From: Amanda Scholes on behalf of Planning.Responses
Sent: 10 February 2021 11:05
To: Planning Scanning
Subject: FW: Y/113/20/DOC - Land South of Ford Lane and East of North End Road, Yapton - CONDITION 11

We do not recommend discharge of condition 11 at this time. An updated maintenance manual and drainage statement have been provided to us, none of these are on the public planning portal yet.

Are you satisfied with the plans and documents that you have received for **Condition 11** of discharge of condition application Y/113/20/DOC which are set out below:

18-344/821

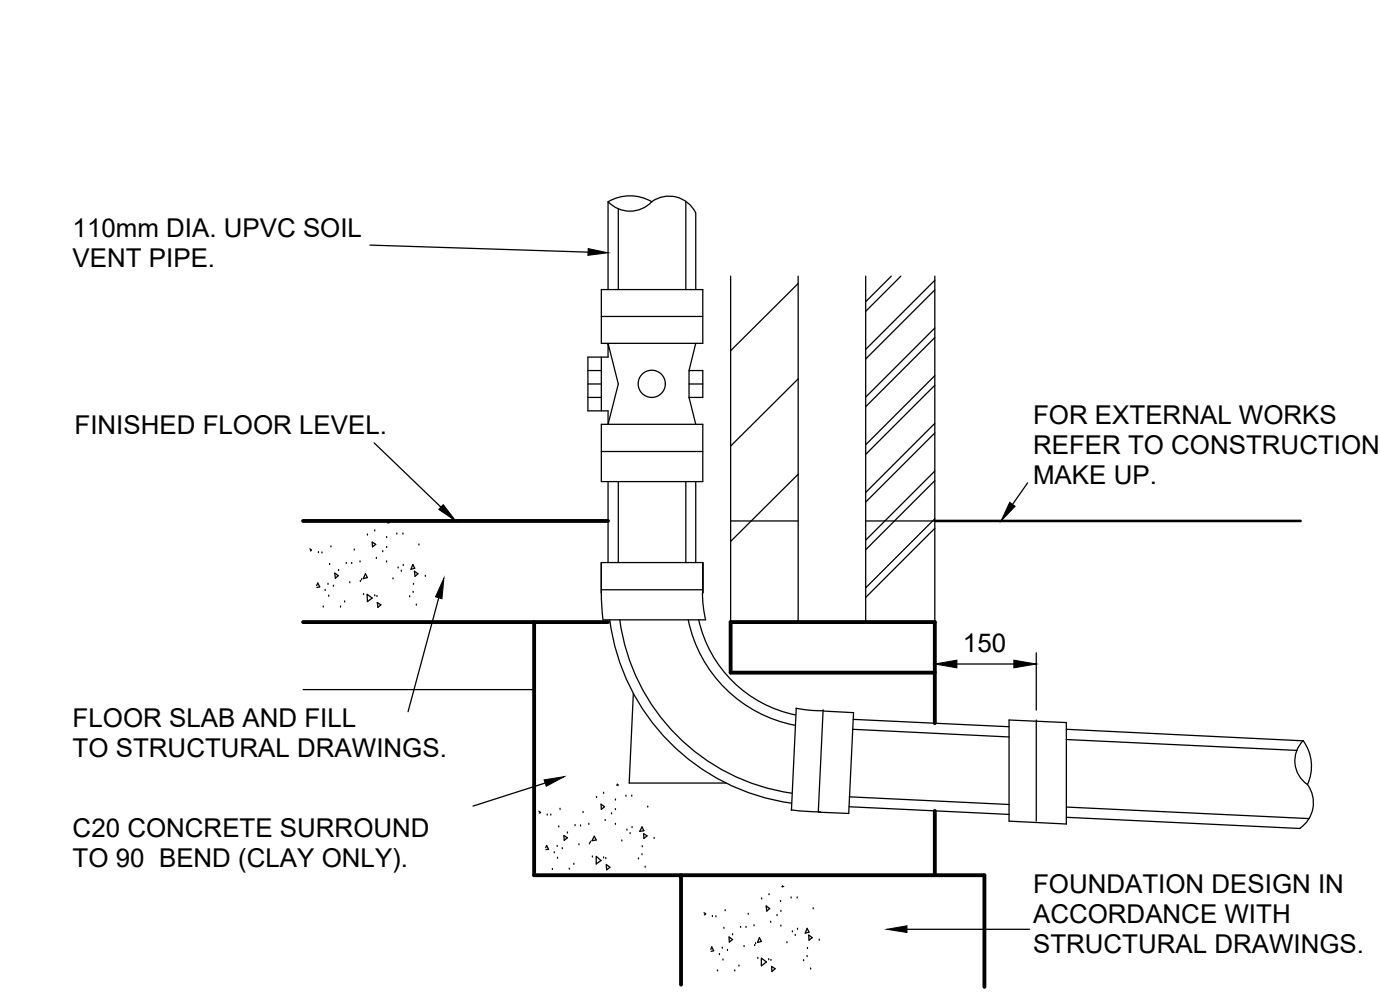
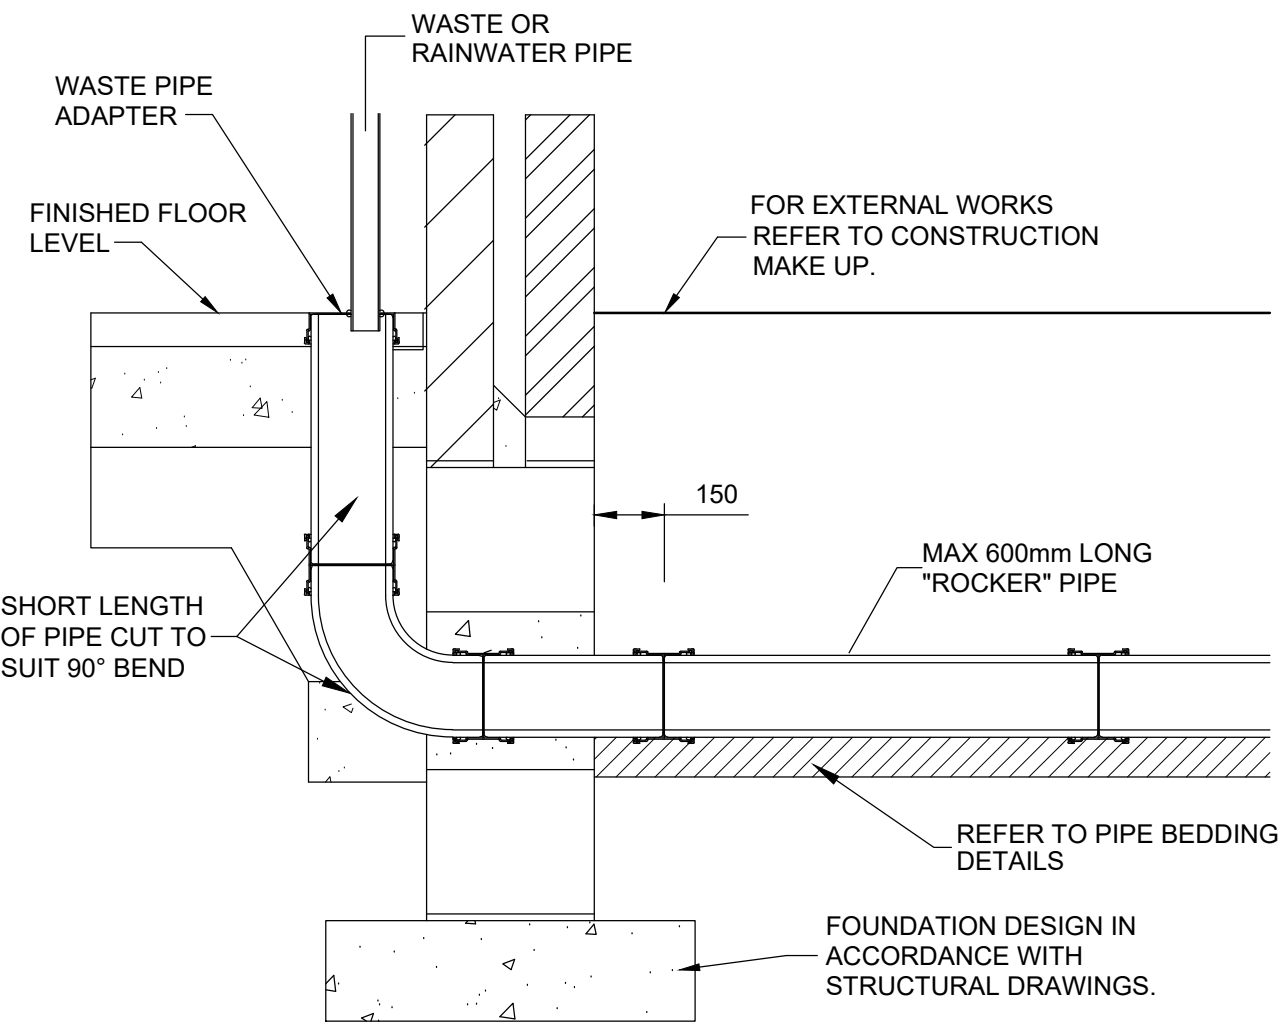
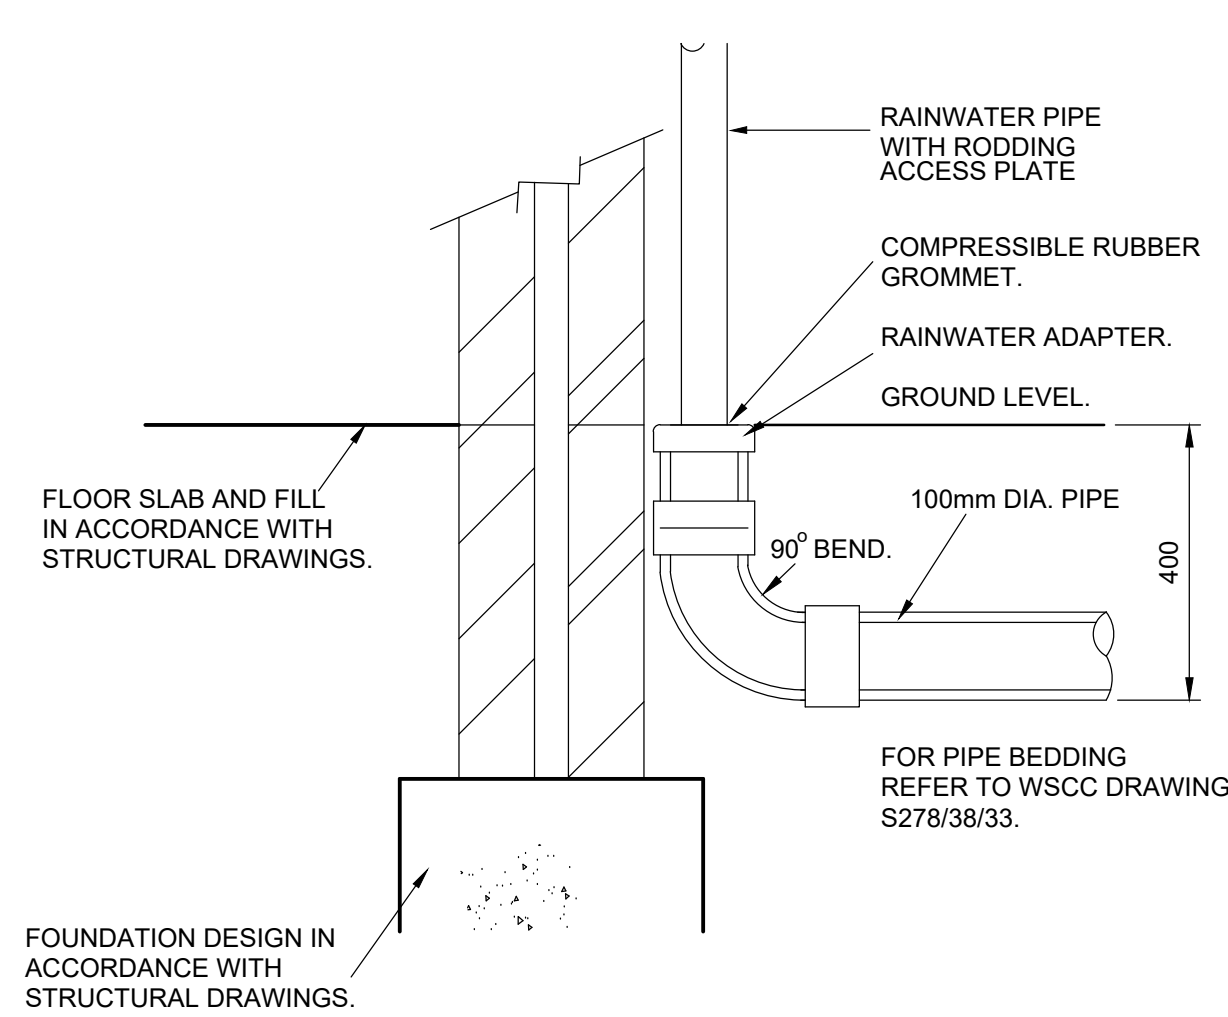
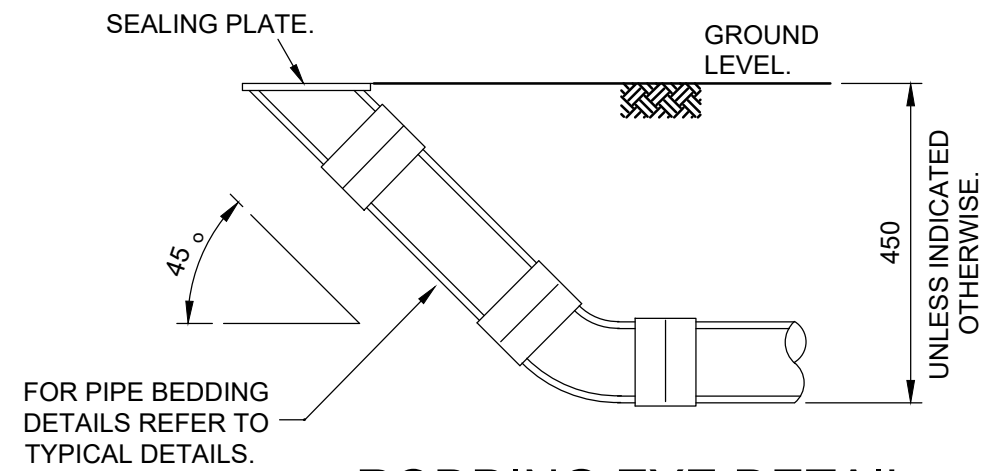
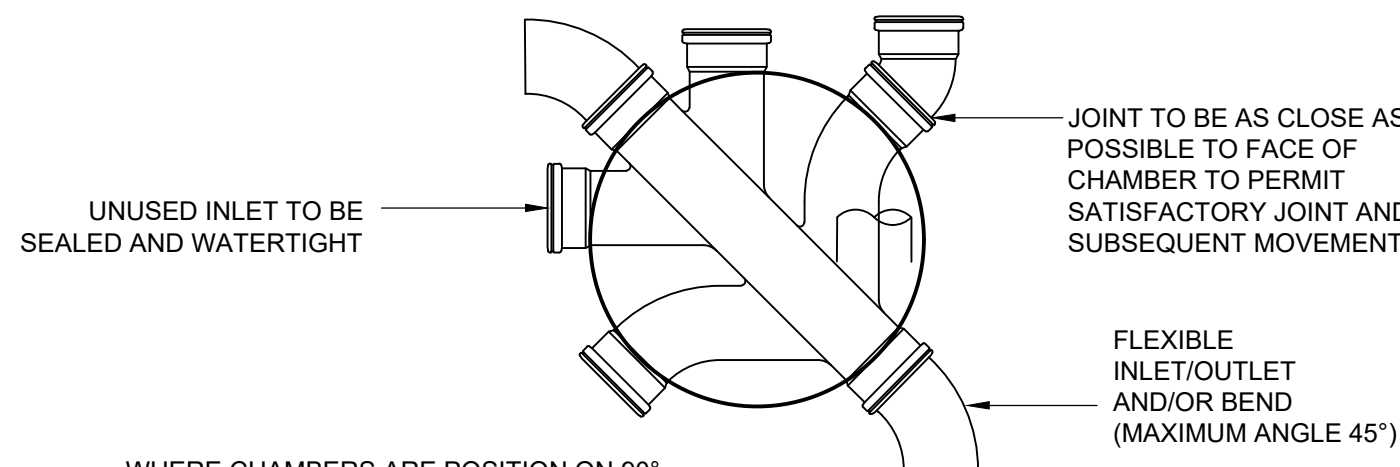
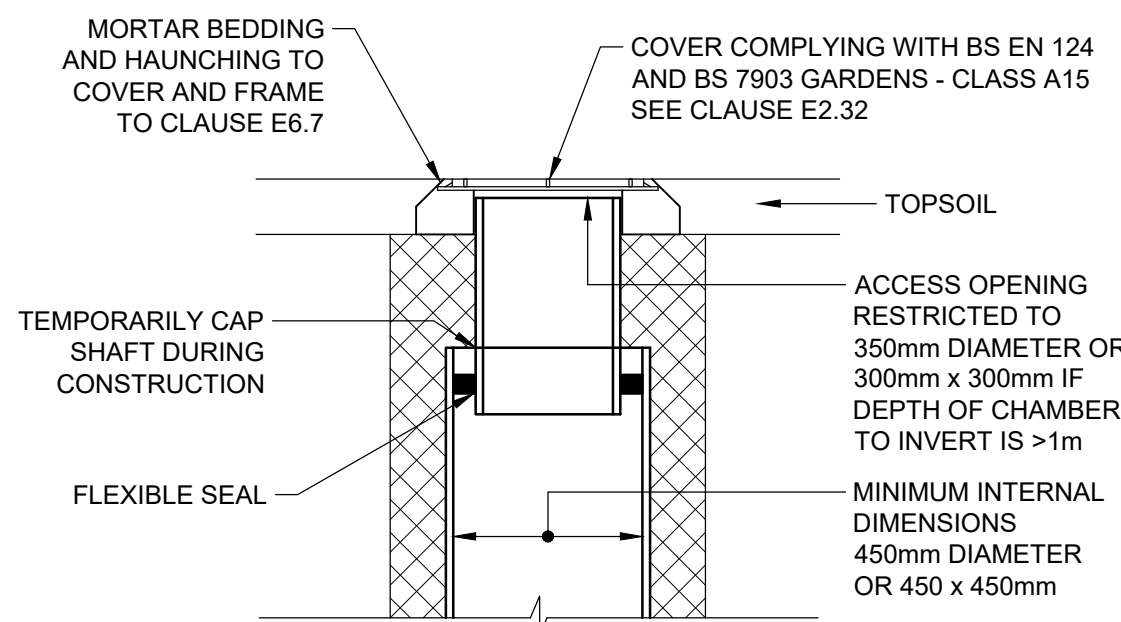
13. Your layout plans show baffles are to be provided in some locations. The construction details are labelled as check dams, but from the construction detail it appears that these are to fully separate sub base areas- consider changing name as check dam or baffle implies water can spill over.

18. Please specify no/ reduces fines for sub-base materials. I would prefer to see the proposed type of material also specified.
19. Please add sand bedding and permeable geotextile surround to the basin sections to clearly show that granular material will be kept out of the crates.
